# Rezoning Transportation Analysis

Petition Number: Insert Zoning Petition #2022-005

Revision Log:	Date	Description
	06-23-22	First Review (TM)
	05-24-23	Second Review (TM)

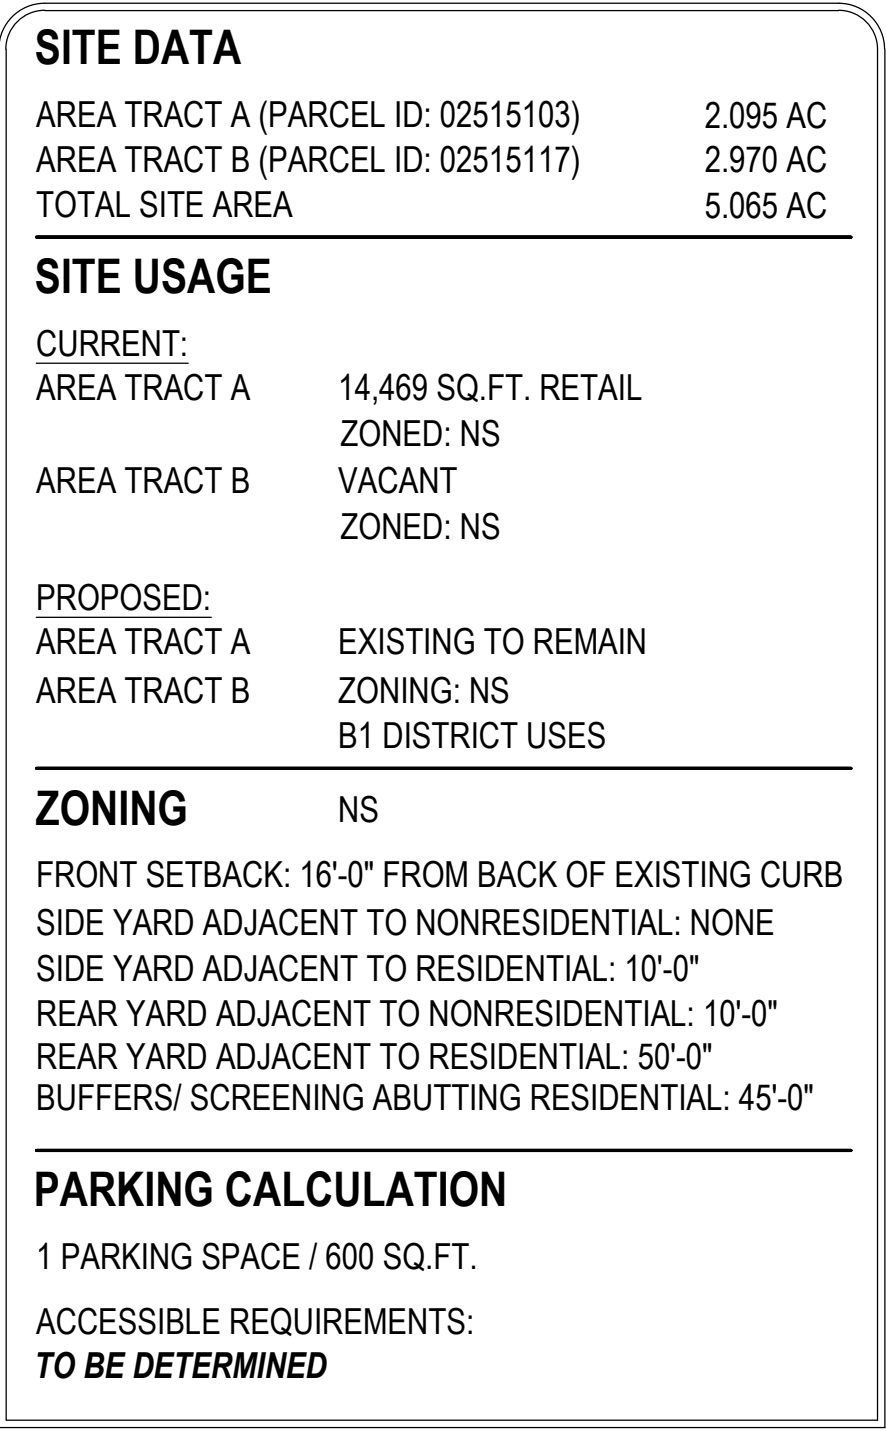
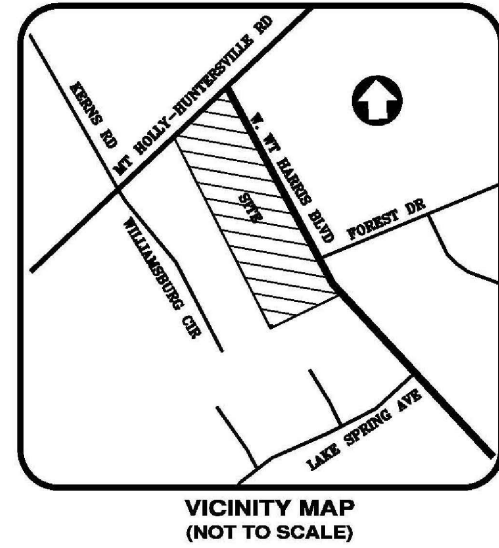
1. ~~**Curbline:** The proposed zoning district has a setback measured from back of the future curbline.~~
  - a. ~~**W T Harris Boulevard:** Location of curb and gutter is 33' from the centerline of W T Harris Boulevard.~~

~~Label and dimension the curb and gutter from the centerline for each road on the site plan.~~
2. ~~**Traffic Study:**~~

3. ~~Revise site plan and conditional note(s) to commit to dedicate a minimum of 50 feet of right of way from the road centerline. The site plan shall label and dimension the right of way from the road centerline. If the proposed multi-use path is located outside of the right of way provide sidewalk utility easement located 2 feet behind the multi-use path.~~

4. ~~Per coordination with NCDOT, revise site plan and conditional note(s) to commit to widen WT Harris to provide two southbound through lanes fronting the site that tie into the existing two through lanes just south of project. In lieu of widening for an additional through lane, a right turn lane can be installed on WT Harris at the site access.~~

5. ~~Revise site plan to show access points for each proposed area from the existing access road.~~
6. ~~Revise site plan to commit to installing 8-foot planting strip and 12-foot multi-use path on WT Harris per Chapter 19. The wider sidewalk also meets the Charlotte Walks Policy and City of Charlotte BIKE Policy.~~

7. ~~A site plan note(s) specifying dedication and fee simple conveyance of all rights of way to the City before the site's first building certificate of occupancy is issued as needed. CDOT requests rights of way set at 2' behind back of sidewalk where feasible.~~

8. ~~Revise site plan and conditional note(s) to commit to reconstructing the site access driveway to meet standard CLDSM driveway detail 10.25E or 10.28. The site plan shall callout and dimension the driveway at the ROW line.~~
